From: Sam Pinkus [REDACTED]
Sent: 10 February 2021 10:57
To: Raymond Cole <Raymond.Cole@arun.gov.uk>
Cc: Kate Little [REDACTED]
Subject: WA/85/20/DOC - Condition 5 Phasing Plan

We have now had an opportunity to address the points raised in relation to the above DOC application. Please see attached revised phasing plan.

Drwg. No.	Rev.
FON-TECH-PHA	P

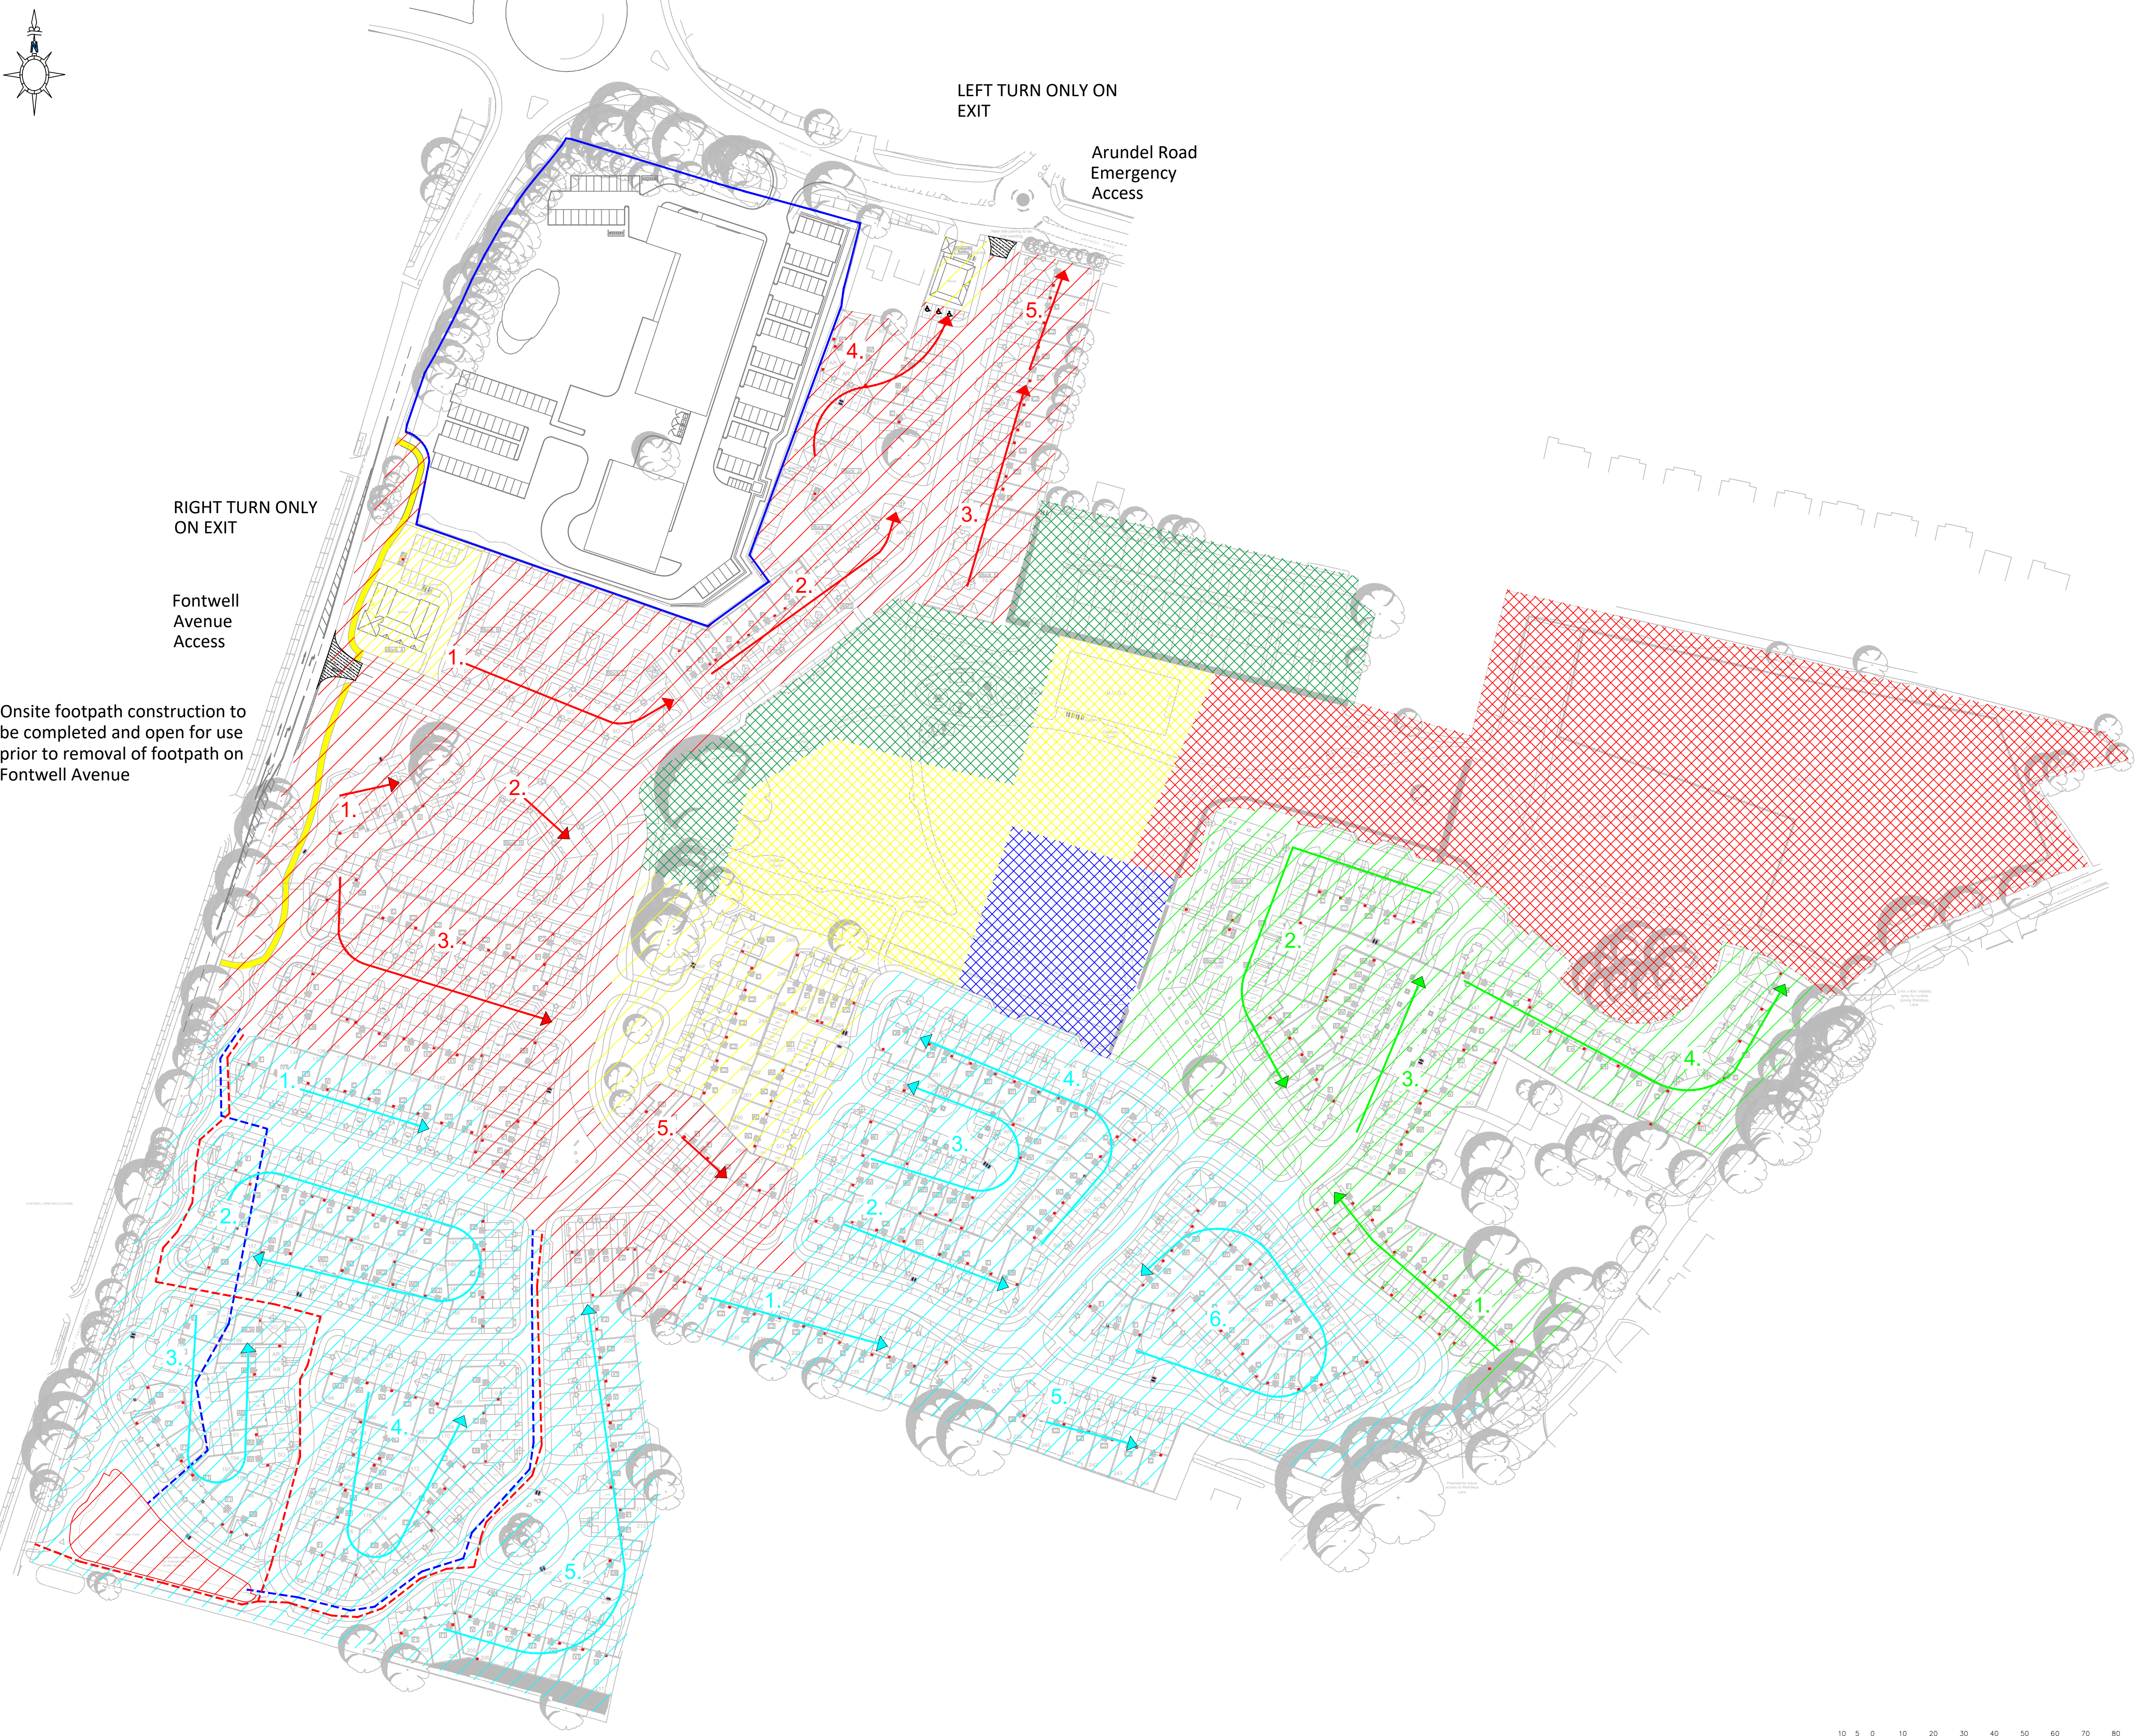
You will note on the revised phasing plan, reference is made to the CMP in which the phasing plan should be read in conjunction with. Therefore, the revised CMP which was re-submitted 27.01.21 considers the details relating to timing of access to be provided onto Fontwell Avenue within phase 1.

The revised phasing plan includes the timing within phase 1 whereby the footpath construction is to be completed prior to the removal of the Fontwell Avenue footpath. In line with section 4.1.3 of the NMU.

Finally, whilst we have considered the request relating to the Footway/Cycle way link onto Wandleys Lane, the health and safety implications would be too severe to enable early delivery. Giving consideration to the compound phasing and public access through what will be a live construction site.
